**CITY OF ALBUQUERQUE
PLANNING DEPARTMENT
August 31, 2011
DRB Comments**

PROJECT # 1002629

RE: Lots 10 & 11, Davidson Addition No.1

Sketch Plat Site Plan
 Scale: 1"=20'

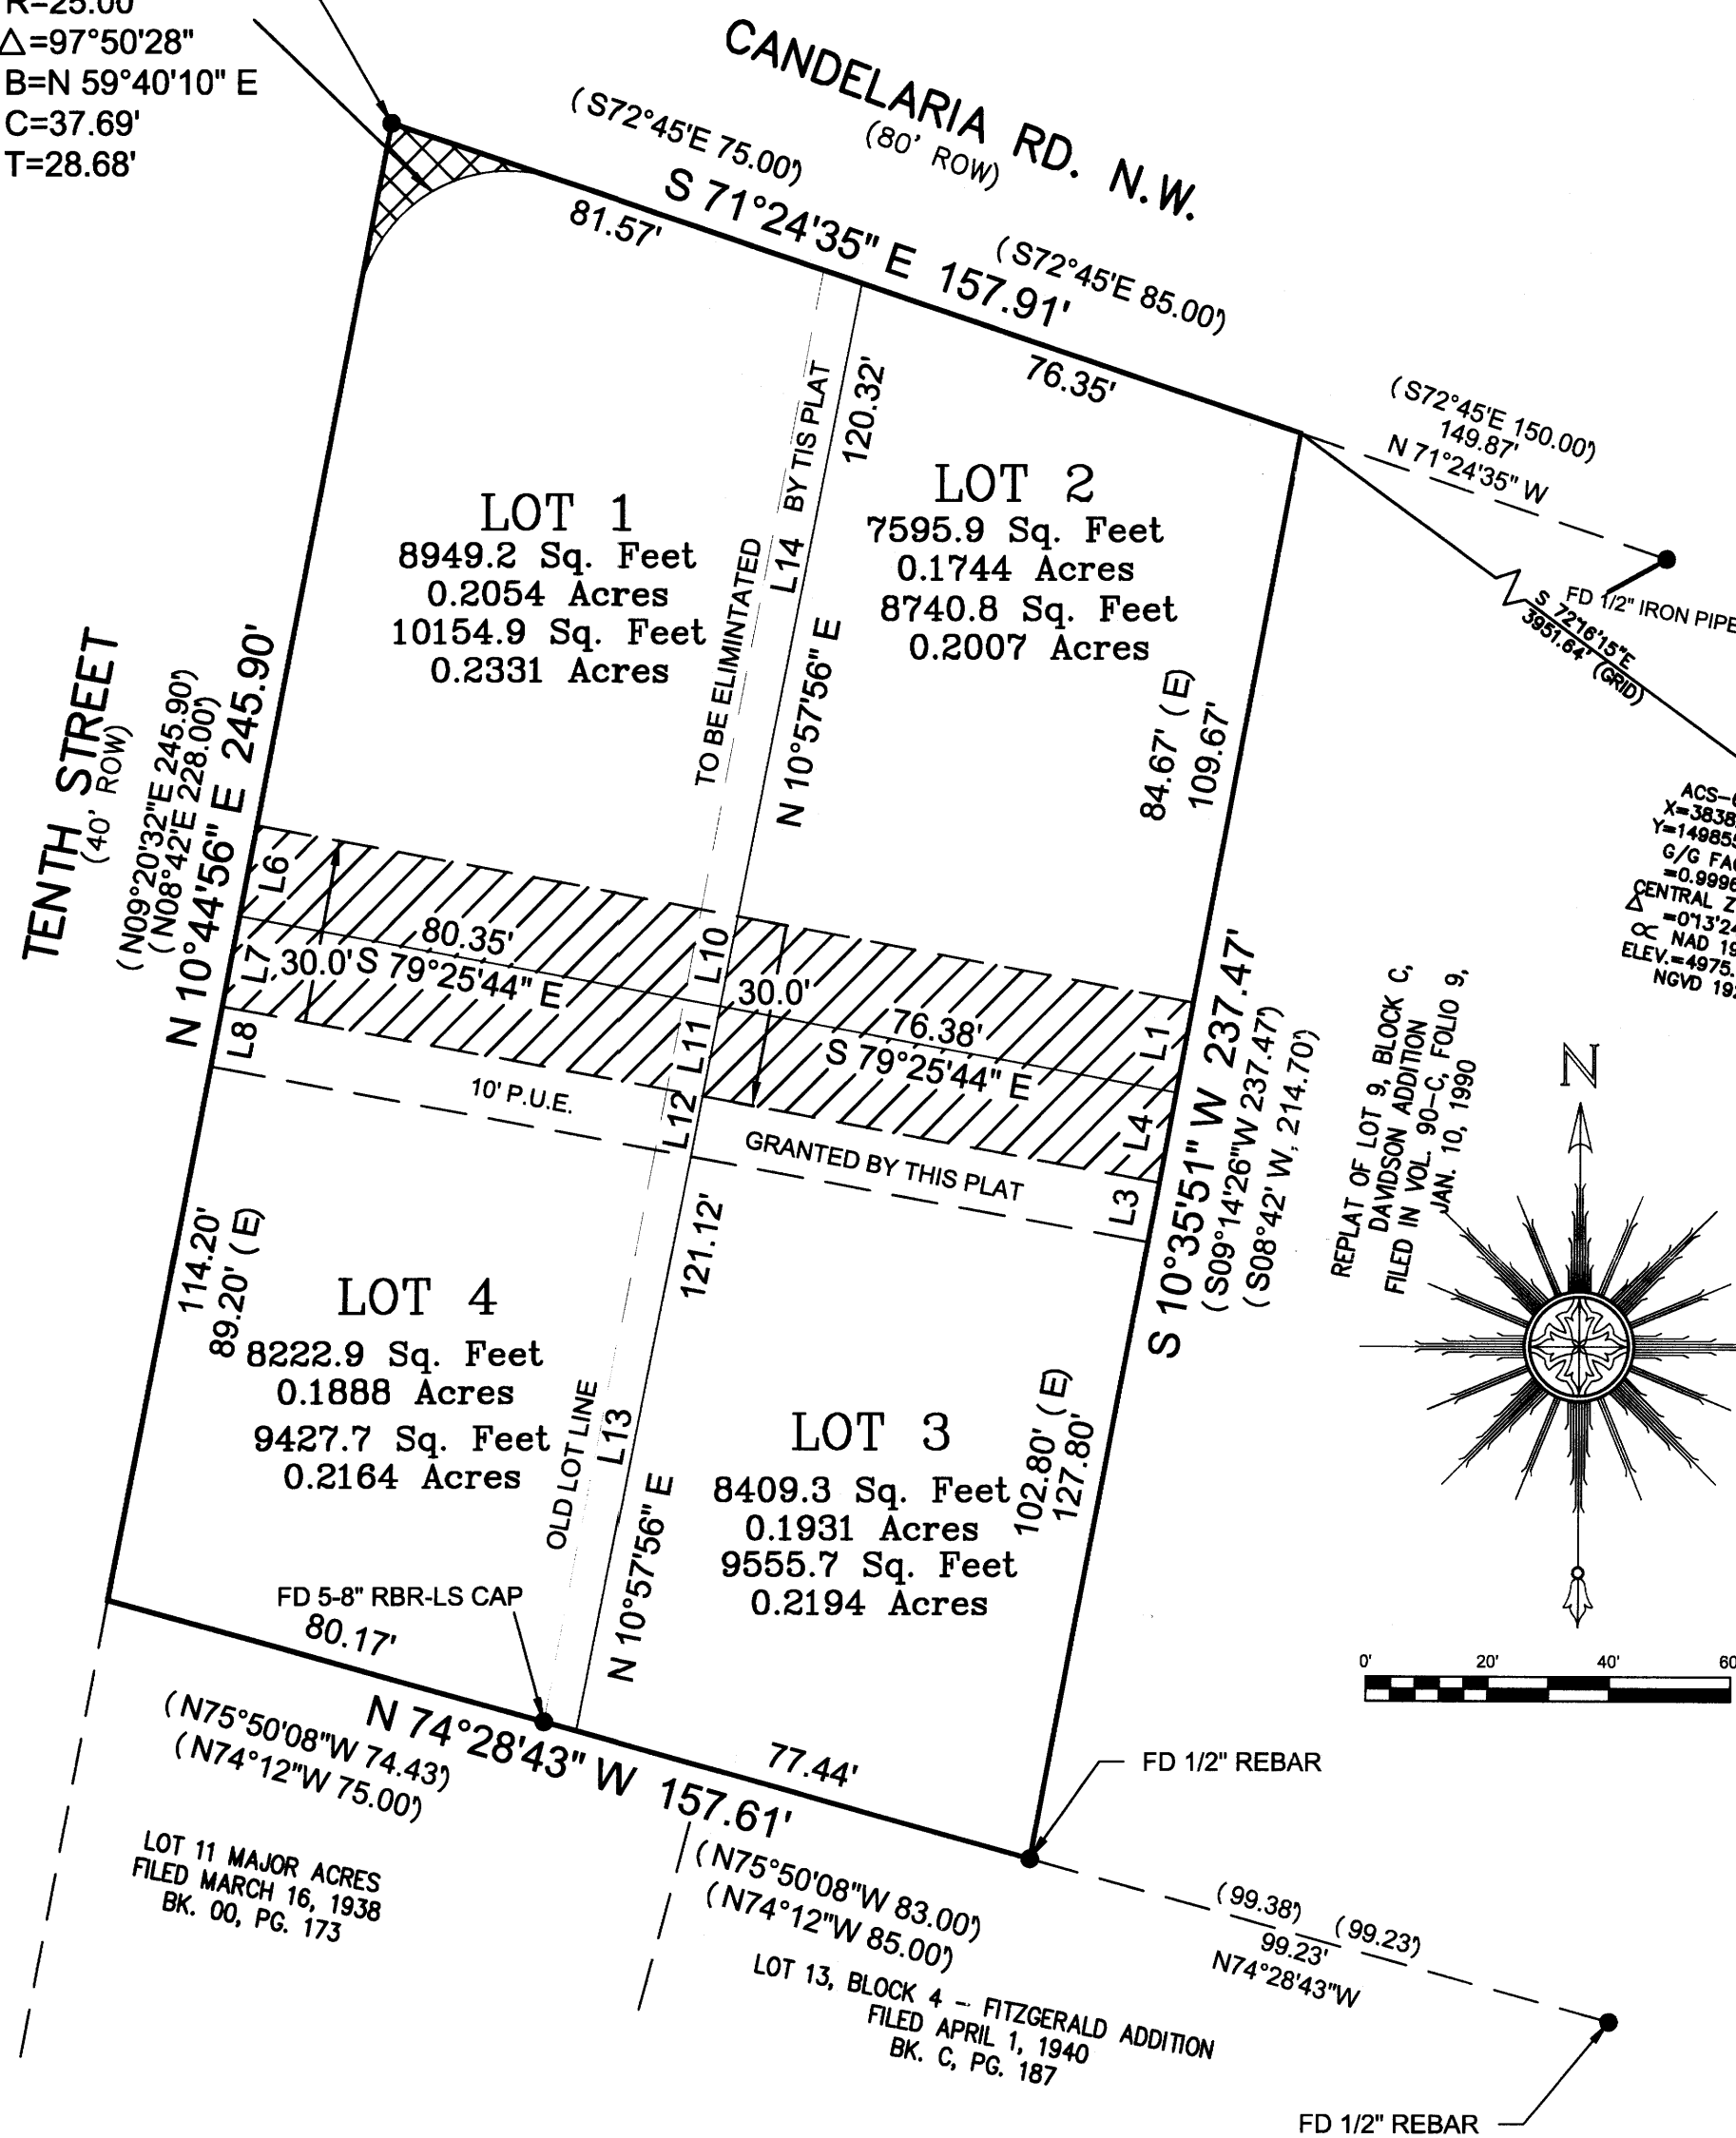
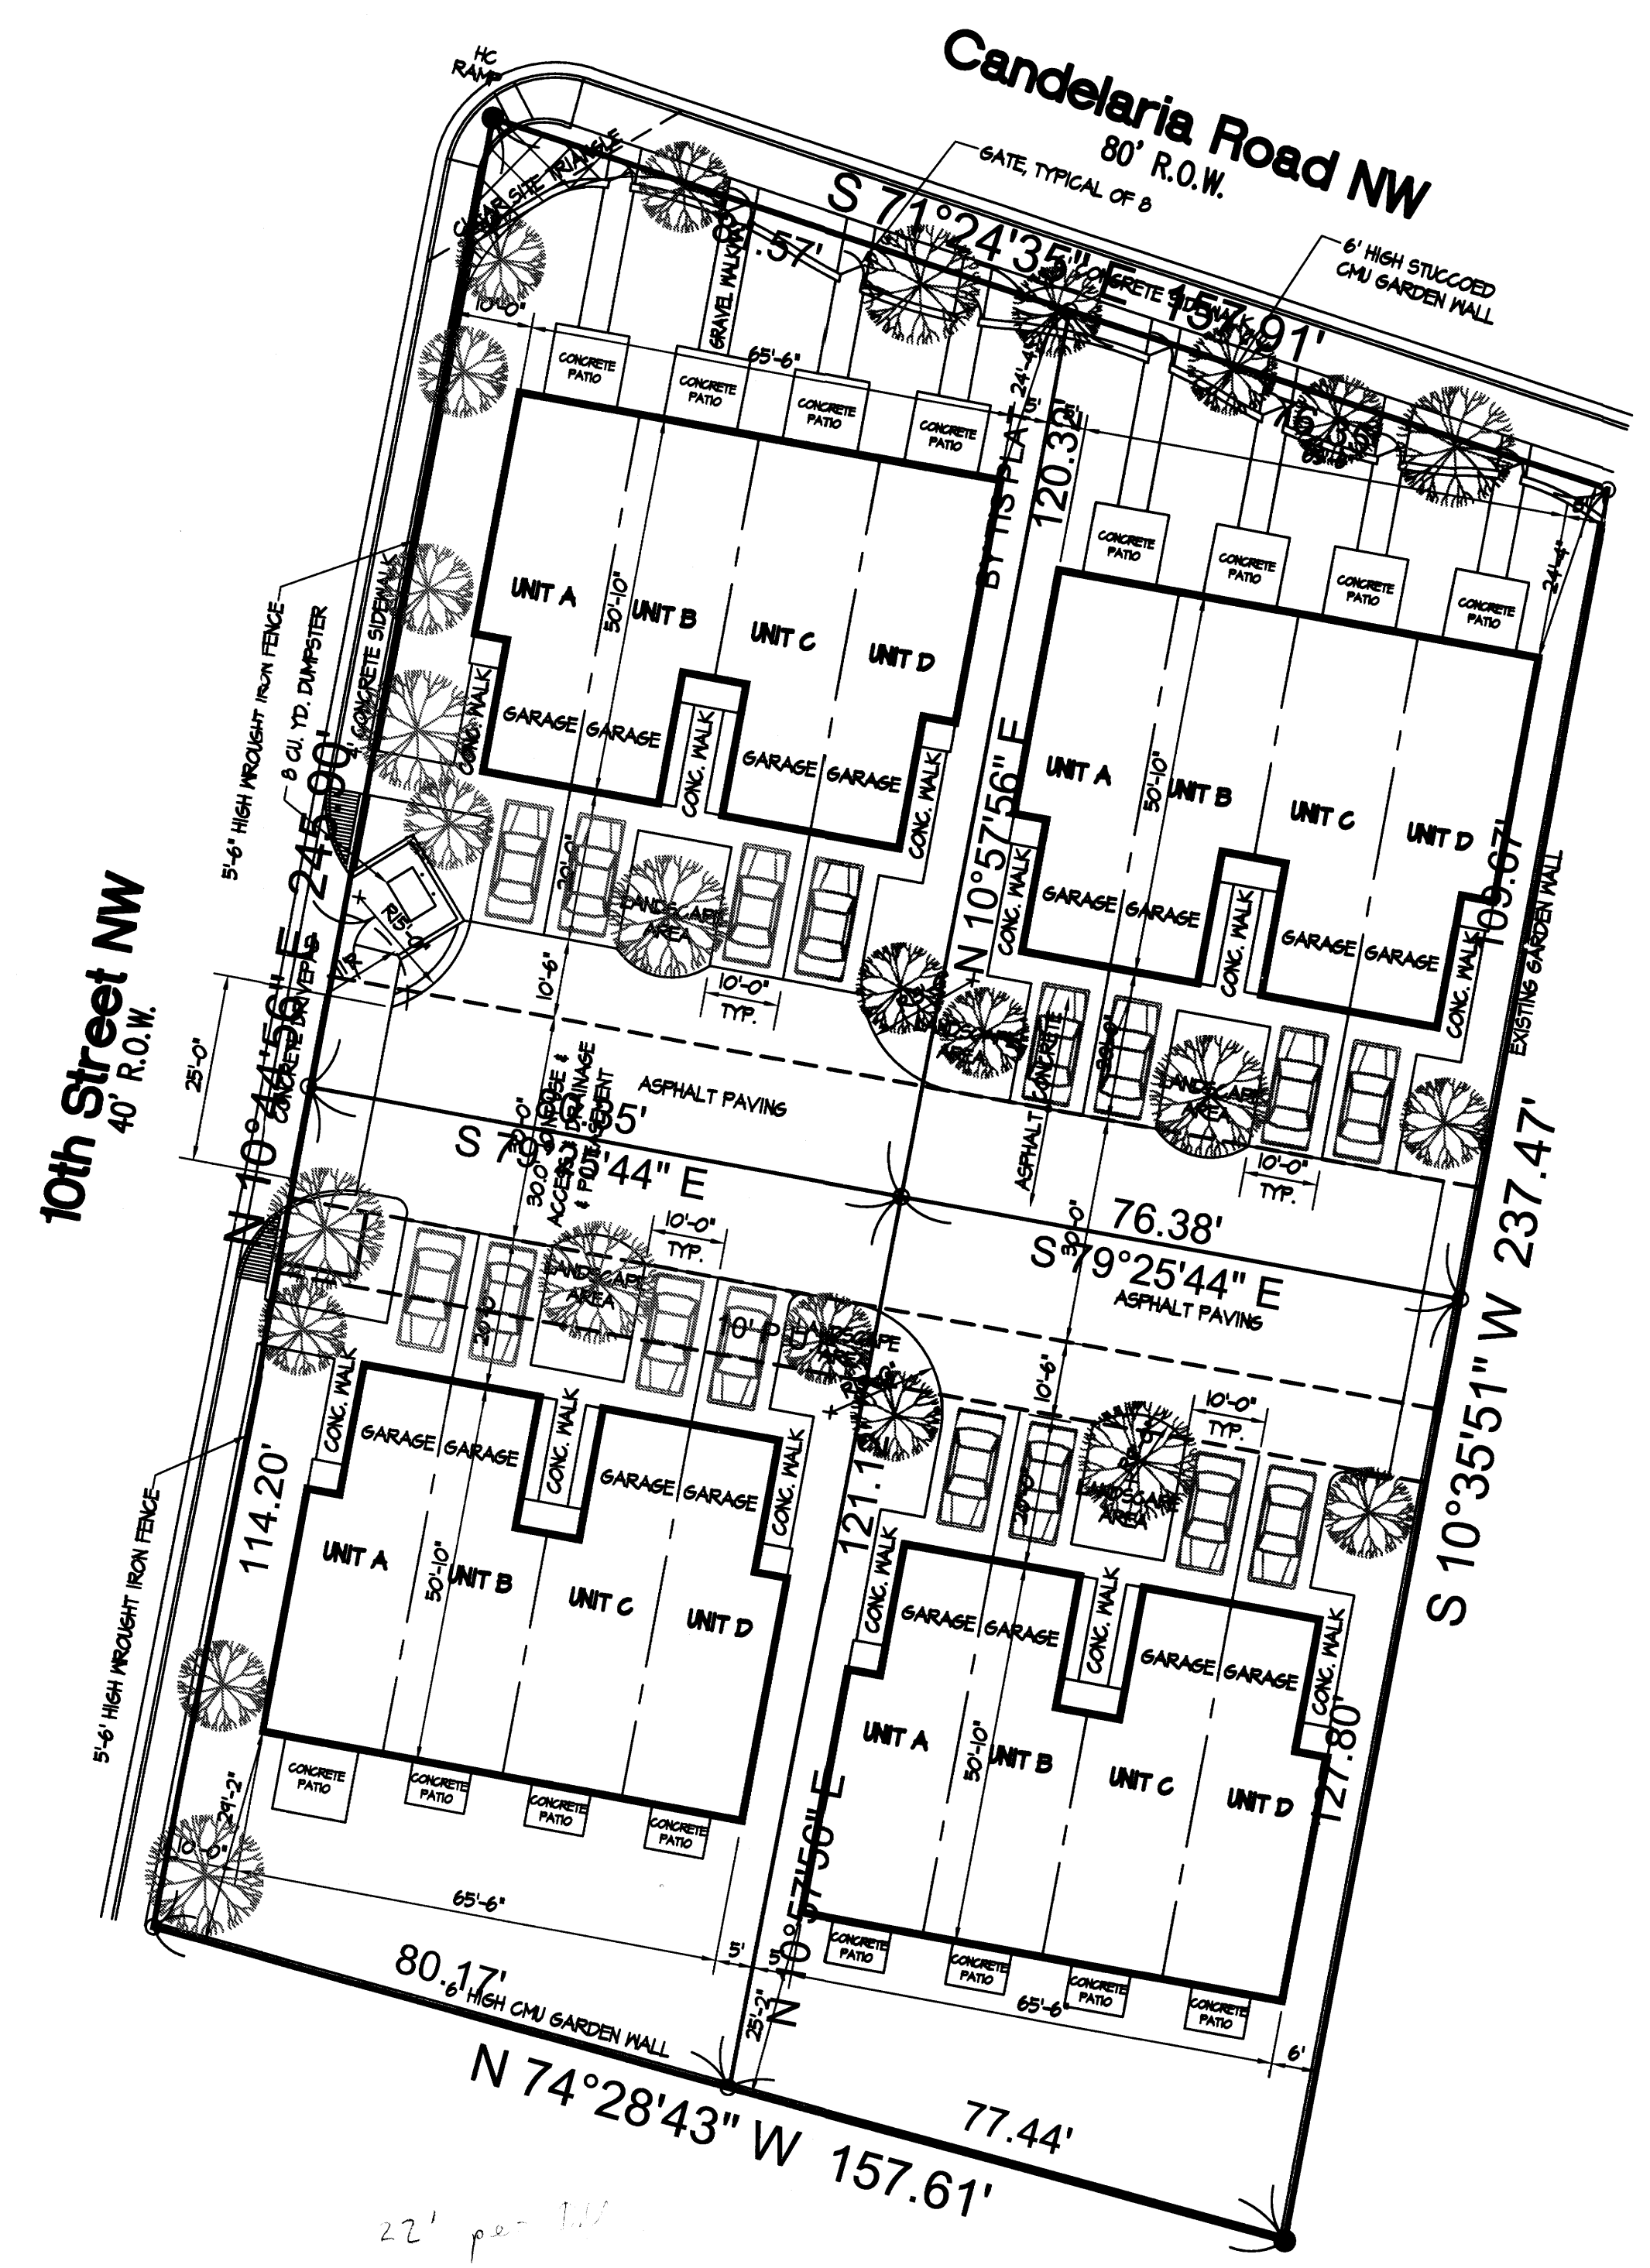
Refer to comments from Transportation Development regarding proposed access. It does not appear that the proposed easement meets DPM requirements for a stub street (needs turnaround) or for separate pedestrian access for the proposed southernmost buildings (for the southeastern lot, a sidewalk connection and Pedestrian Easement would be needed across the southwestern lot).

The proposed plat of four lots could be approved but the proposed development for the two southern lots would require a Setback Variance (Minimum 20 feet for southwestern lot where abuts the R-1 zone to the south – Section 14-16-2-13(F)(2) of the Zoning Code). It appears from aerial photos that the R-1 properties to the south do not meet the 20 foot setback.
